Land at Courtwick, Littlehampton, West Sussex – Submission under S106A (Permission LU/355/10)
planning ref: LU/241/18/PO

PLAN OF CENTRAL SQUARE 1:200

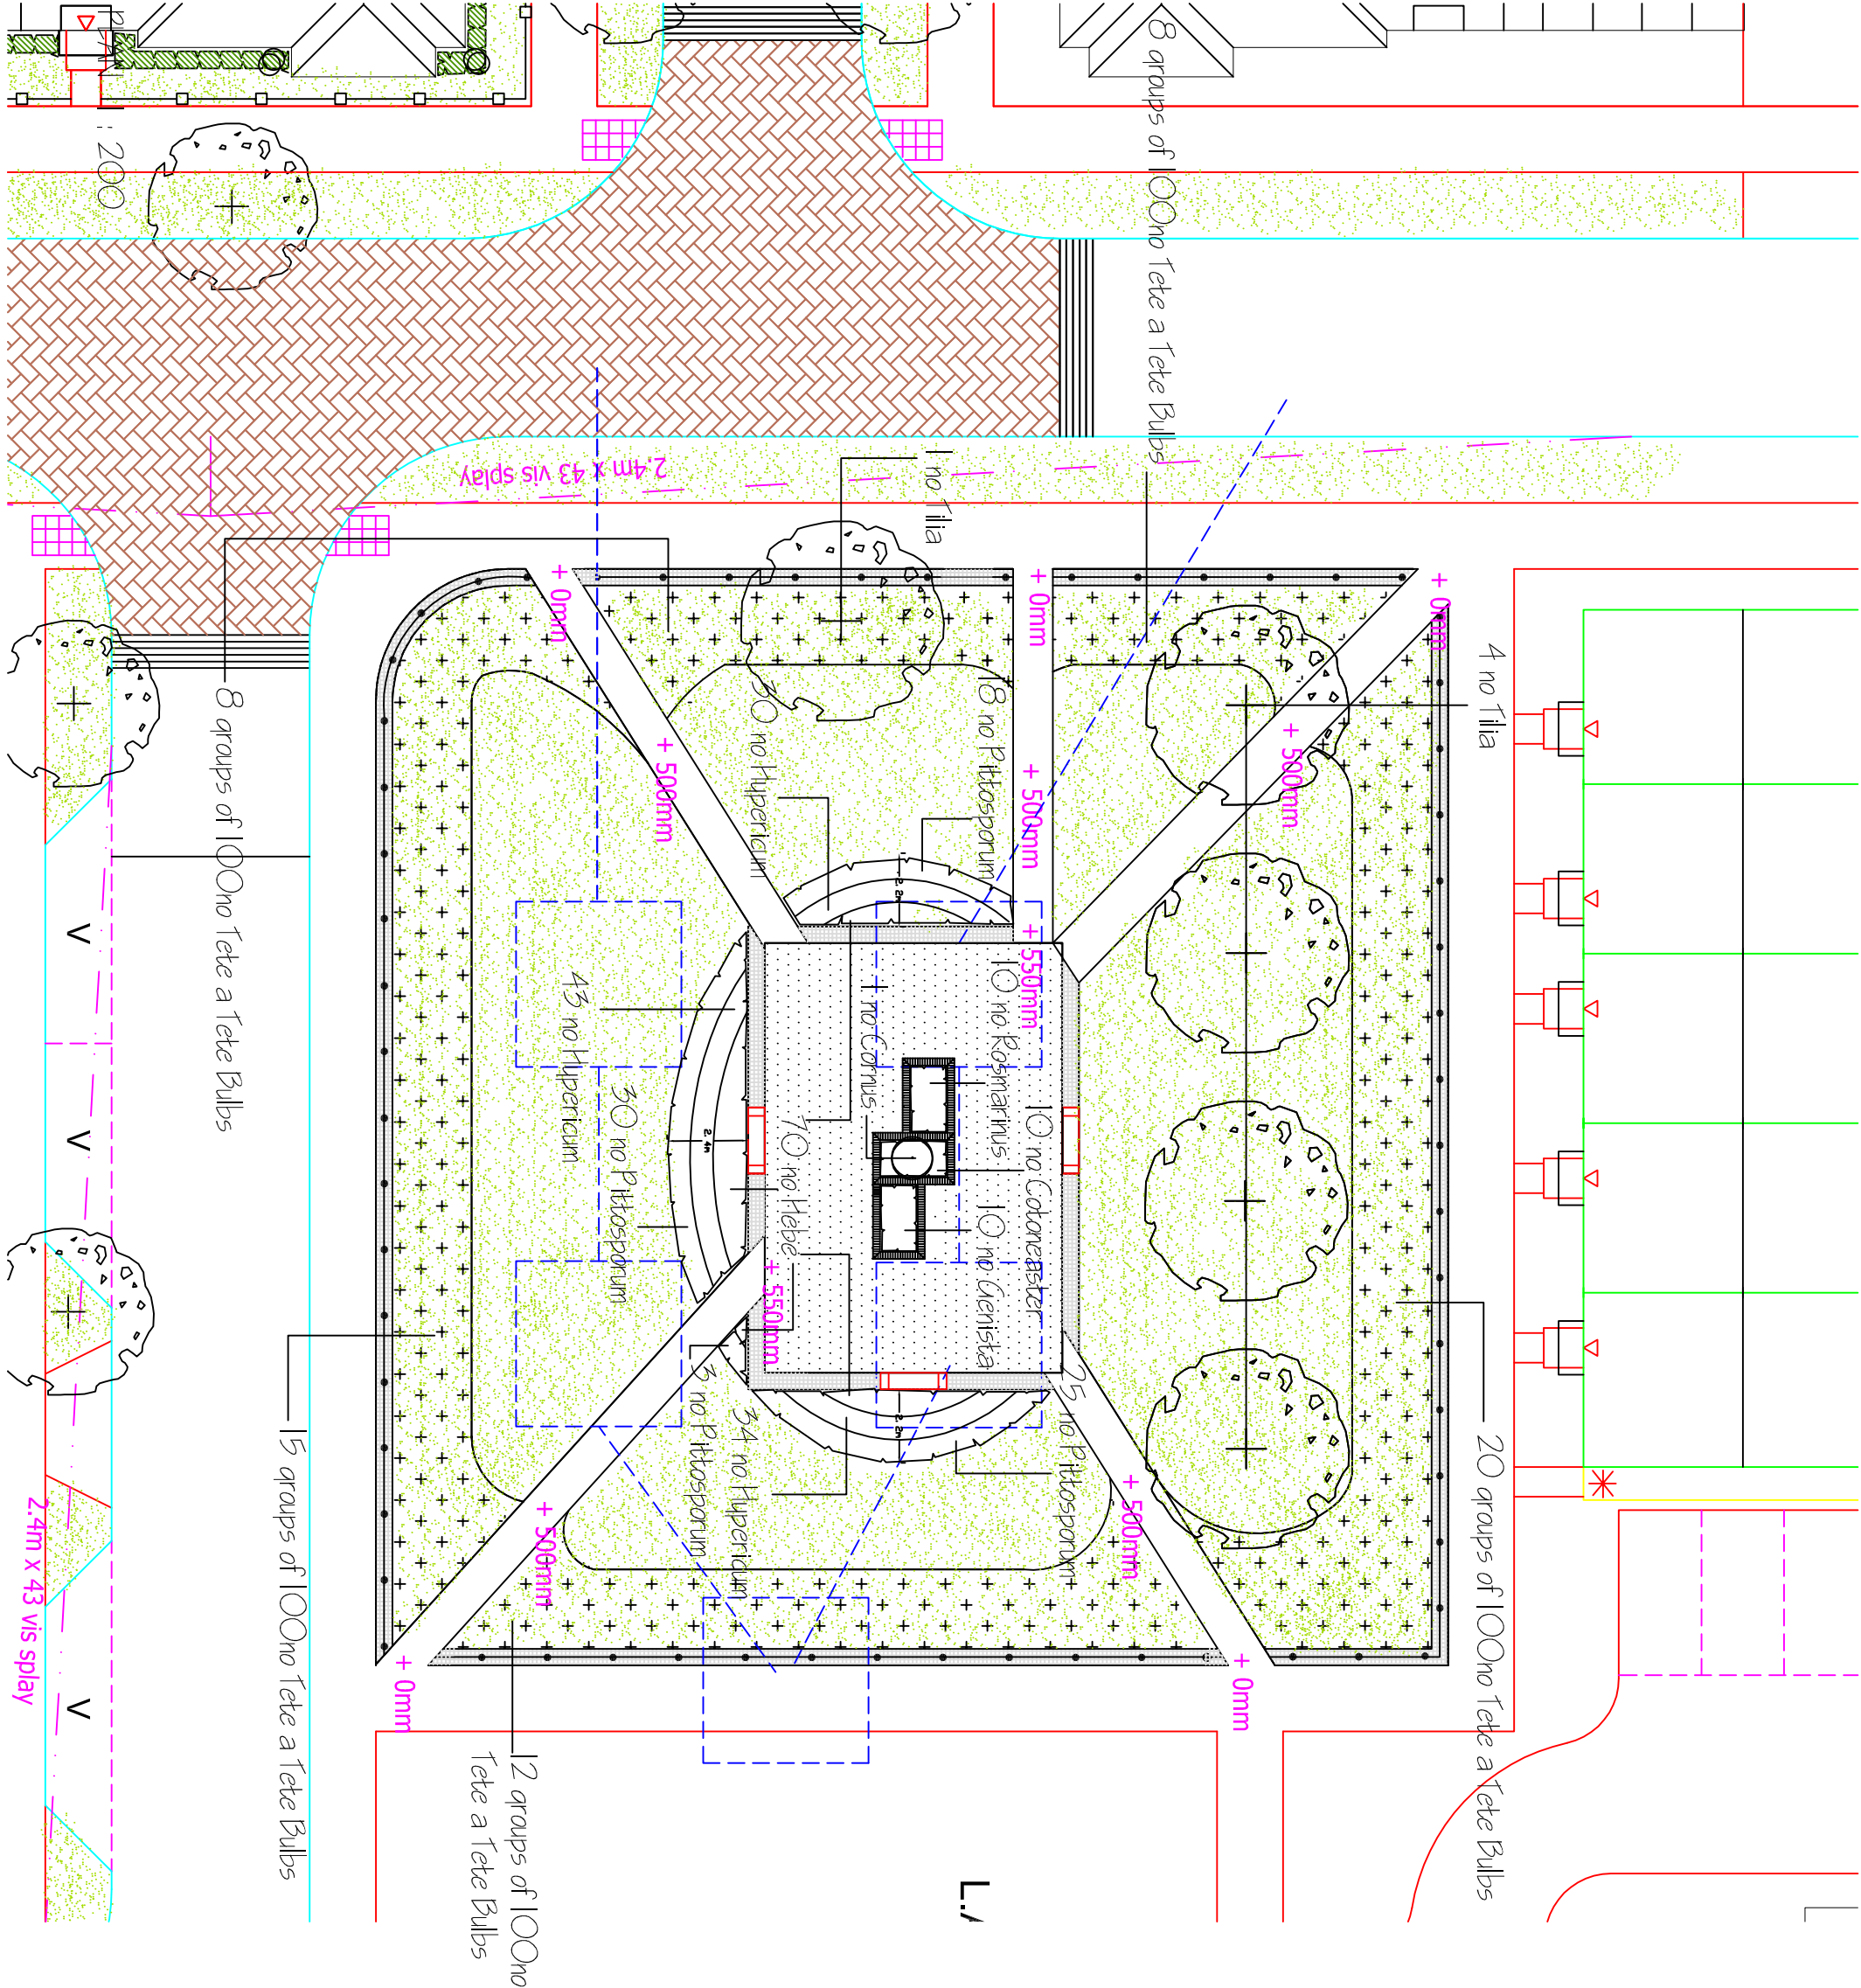
1. Revision of Plan 2 to reflect new location of LEAP and NEAP.
2. Amendment to Schedule 2 Para 17 to adjust trigger (500 dwellings) to 31 May 2019.
3. Amendment to Schedule 2 Para 11 to adjust trigger (450 dwellings) to 31 May 2019.
4. Proposed amendment of Plan 2 removing LEAP 2 and introducing 'Central Square' – Linda Oak Landscape Design drawing 972/07 Rev E – and trigger to 31 May 2019
5. Amendment to Clause 2 and 3 under Schedule 1 to replace with a clause to say, "No provision of this deed shall be enforceable against individual owner occupiers of the dwellings or their mortgagee."
